Application by Highways England for the A303 Sparkford to Ilchester Dualling project
The Examining Authority's written questions and requests for information (ExQ2)
Issued on 22 March 2019

Responses are due by **Deadline 5 (5 April 2019)**

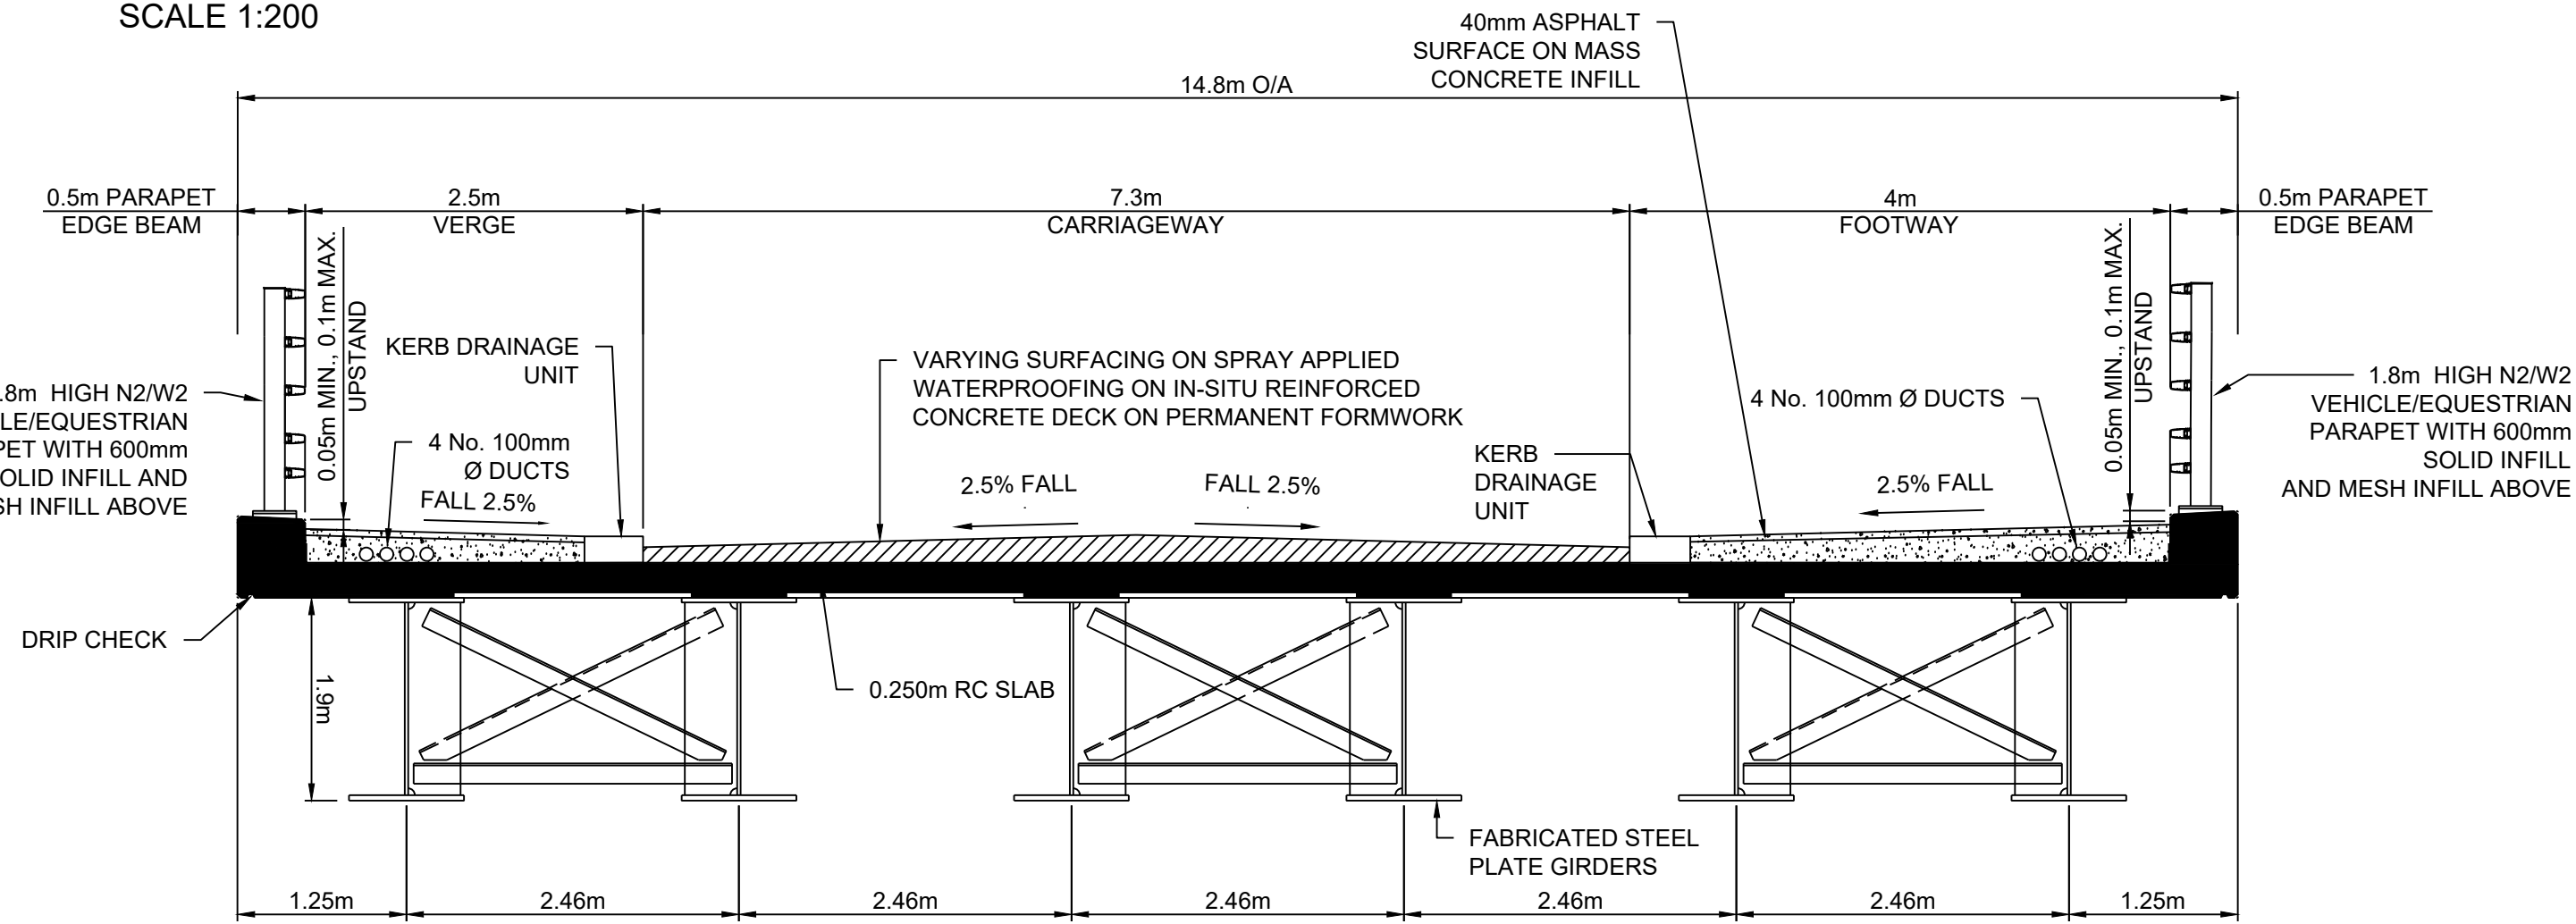
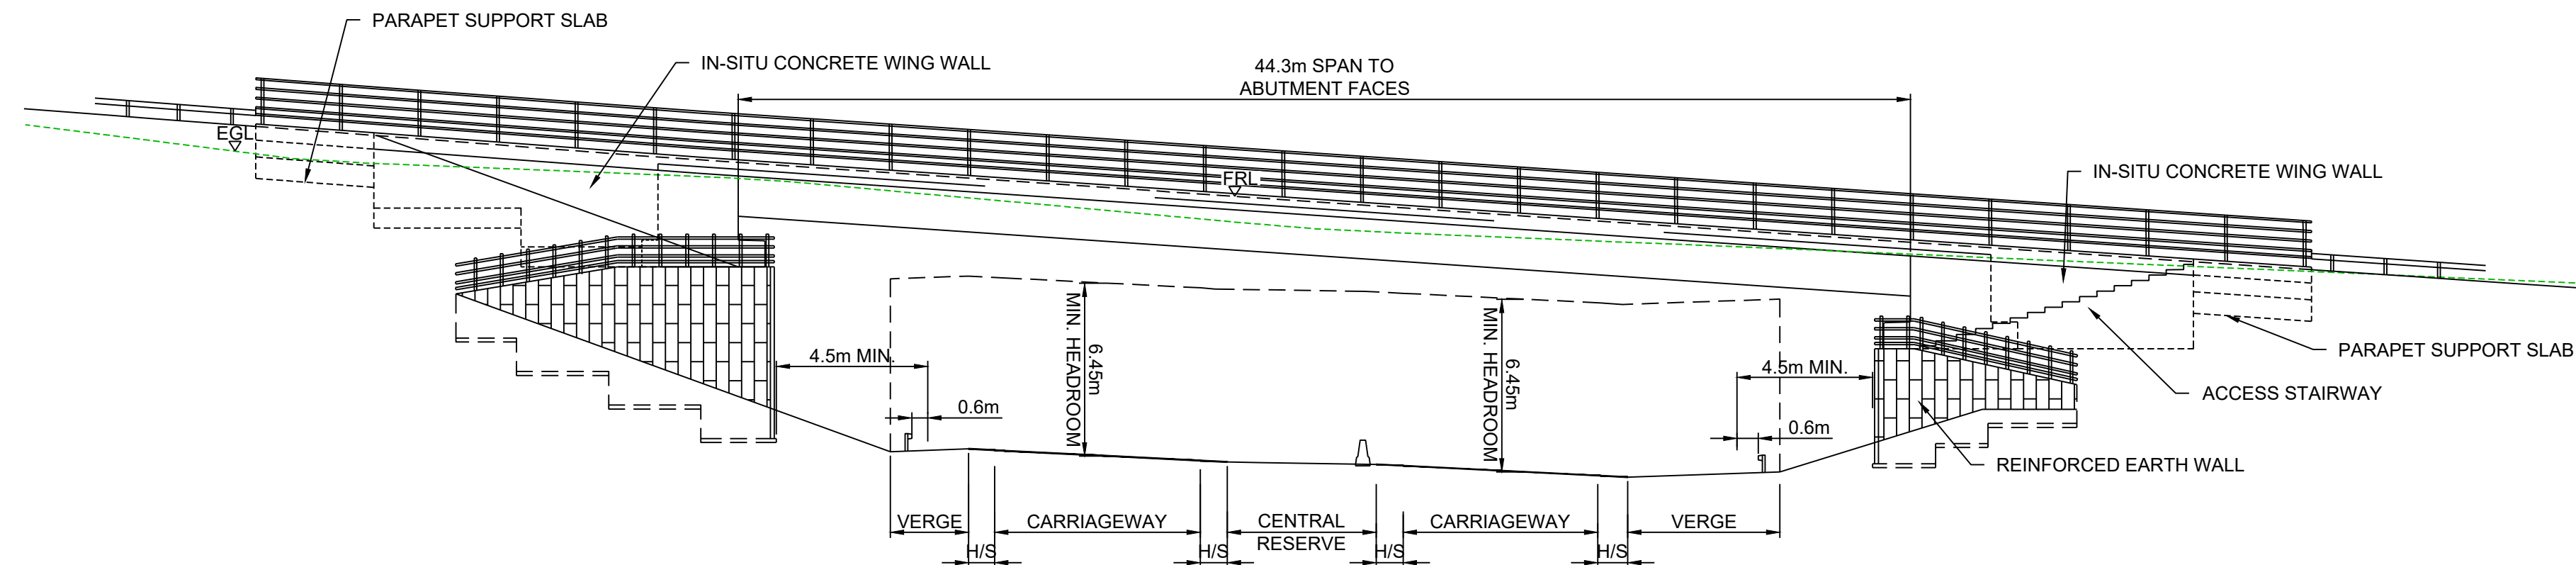
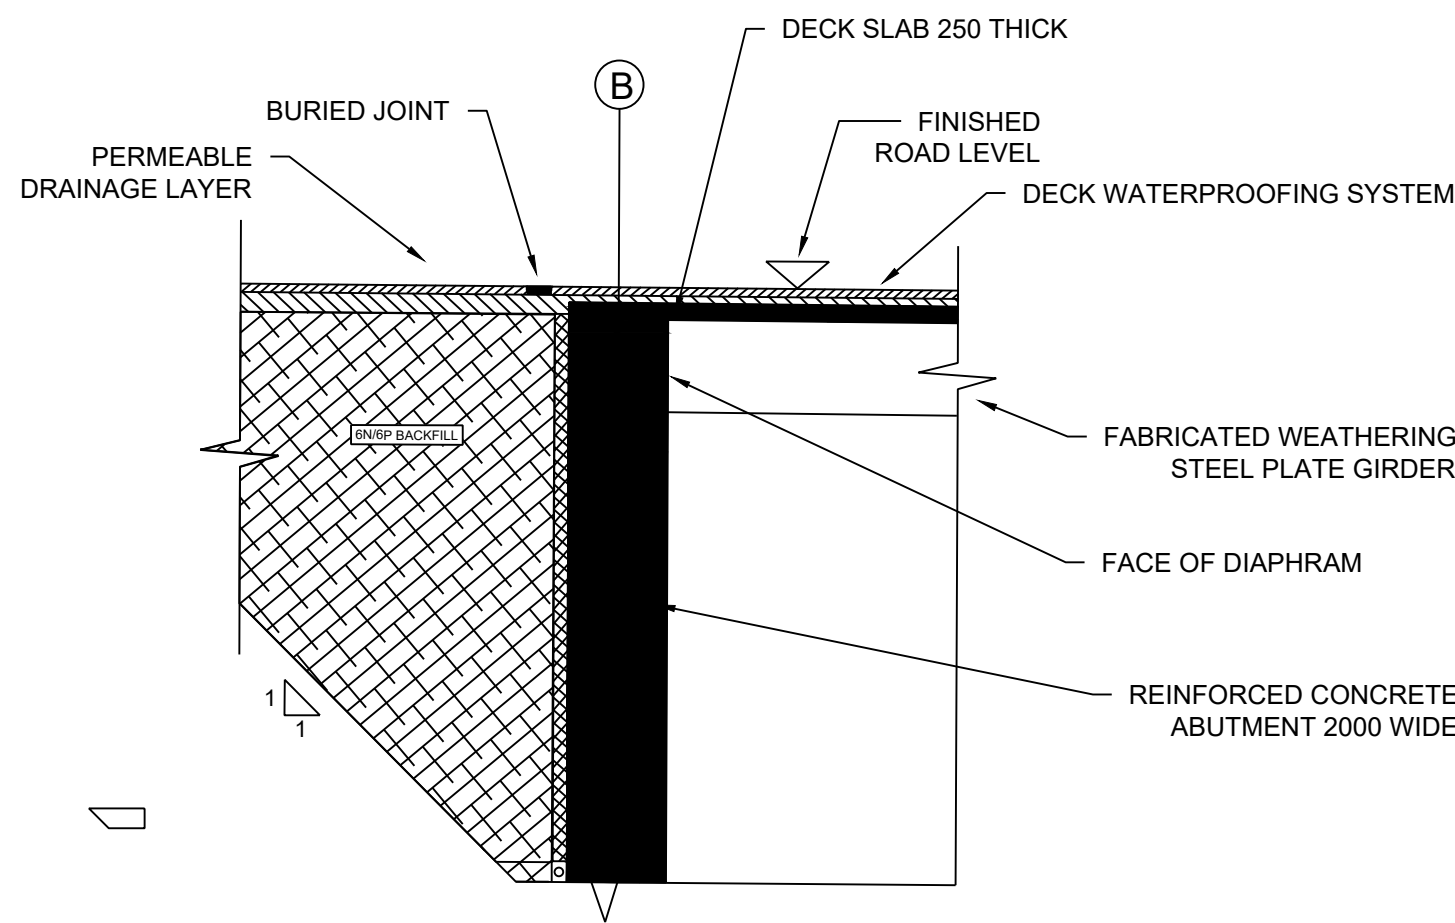
2.6.8	The Applicant	<p>Hazlegrove Underbridge ES figure 2.5 [APP-104] shows the general arrangement of the proposed underbridge. It is unclear from the submitted information what the height and profile of the proposed concrete retaining walls would be.</p> <p>Please could the Applicant submit indicative details of these walls sufficient to illustrate the intended height, profile and appearance.</p>
